AB/49/20/L

55B High Street Arundel BN18 9AJ

Listed building consent to seal off the residential flat from the commercial space & creating a new entrance door through the already existing communal area of 57 High Street.

Proposed Ground Floor Plan
(Showing structure over)
(1:50)

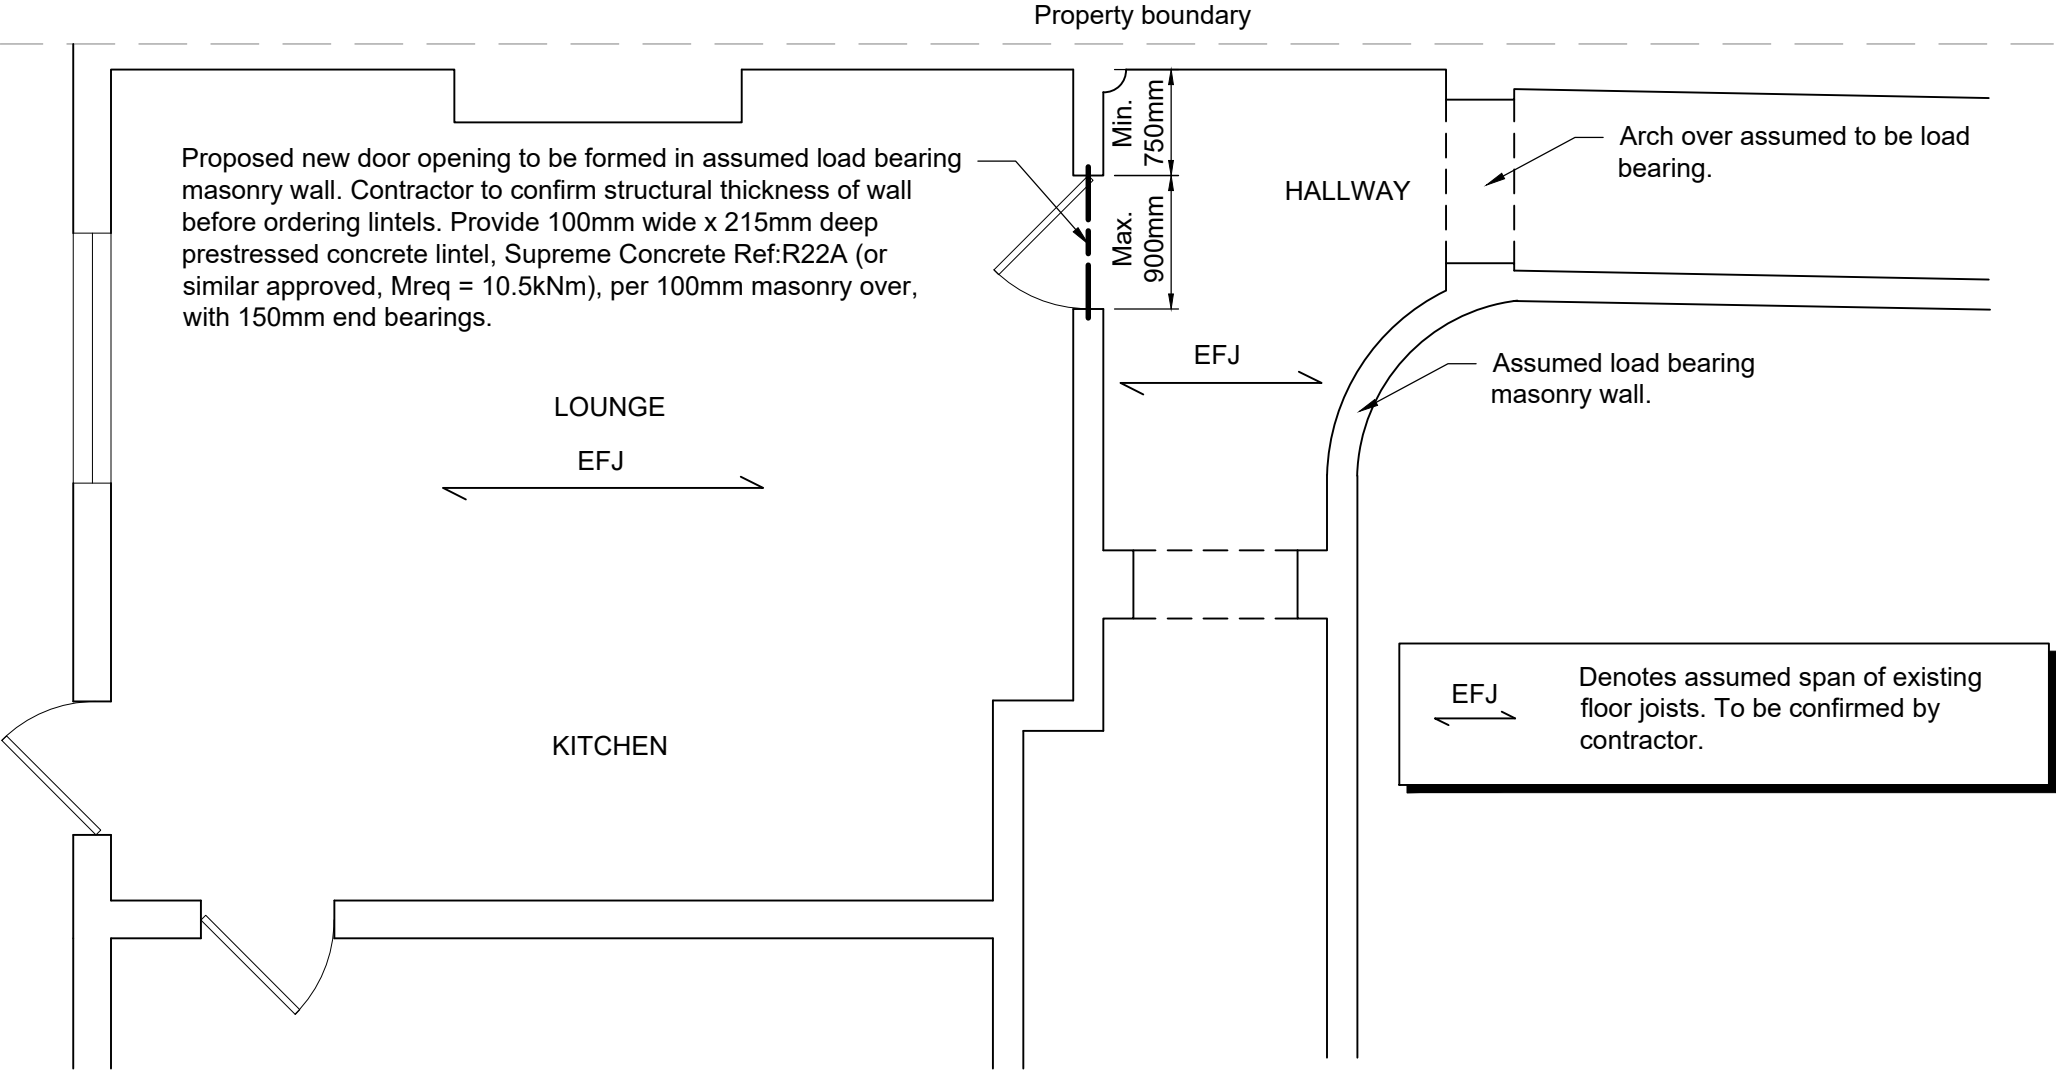
It would appear that the proposal is to provide an independent means of access to the apartment. It is assumed that this is to remove the necessity to utilise the point of access via the commercial premises. This proposal requires another opening to be provided from the entrance hall to number 57 High Street. The entrance hallway is identified within the listing description (as are other aspects of the interior).

There is no information supplied as to how the door(s) would be sealed; would they remain in position, locked and one elevation boarded so as to screen from view, whilst the other is still visible from within the apartment? Also, would the appropriate skirting board be used?

The proposal will result in the introduction of another opening and remove historic fabric. I am not a structural engineer and will have to request that others with knowledge and relevant qualifications confirm if the proposal is acceptable from a structural perspective.

It is also not clear if such a proposal complies with the relevant building regulations and if there is a need for a lobby area or equivalent. Such requirements could affect the layout of the proposal and the rooms associated with the opening. Such alterations will require listed building consent and would not be covered by this consent. They would also require assessment as to their impact.

Proposed New Door (N.T.S)

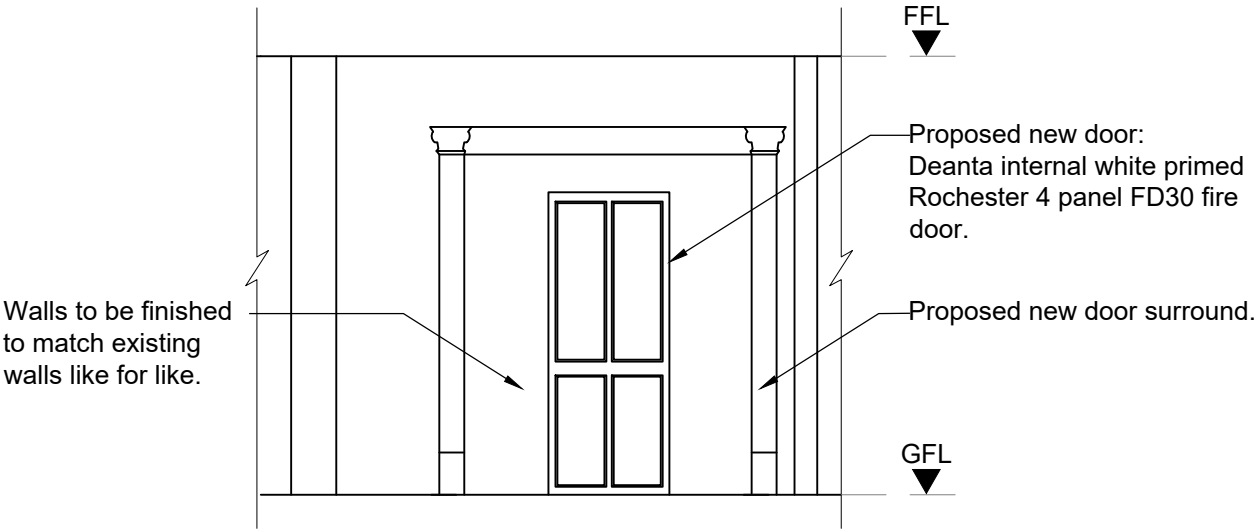
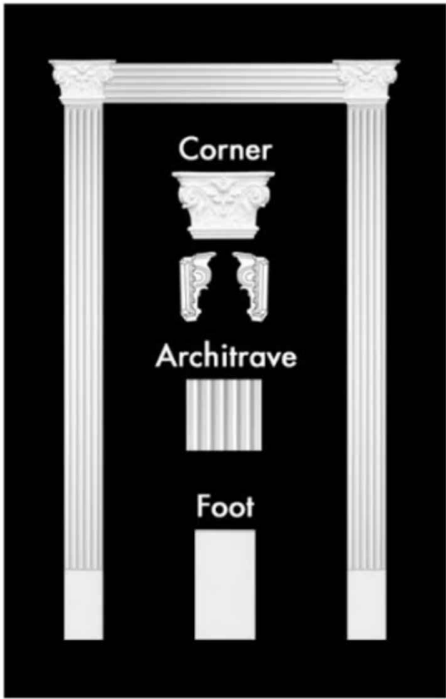
The plans do not provide details of the door itself, nor of the architrave or door furniture. It is suggested that the door and opening should be appropriate for the age and style of the listed building. The last thing we would want to see is a door of inappropriate design and scale for the space proposed. Such information will be required in order to ensure that it is suitable for the listed building.
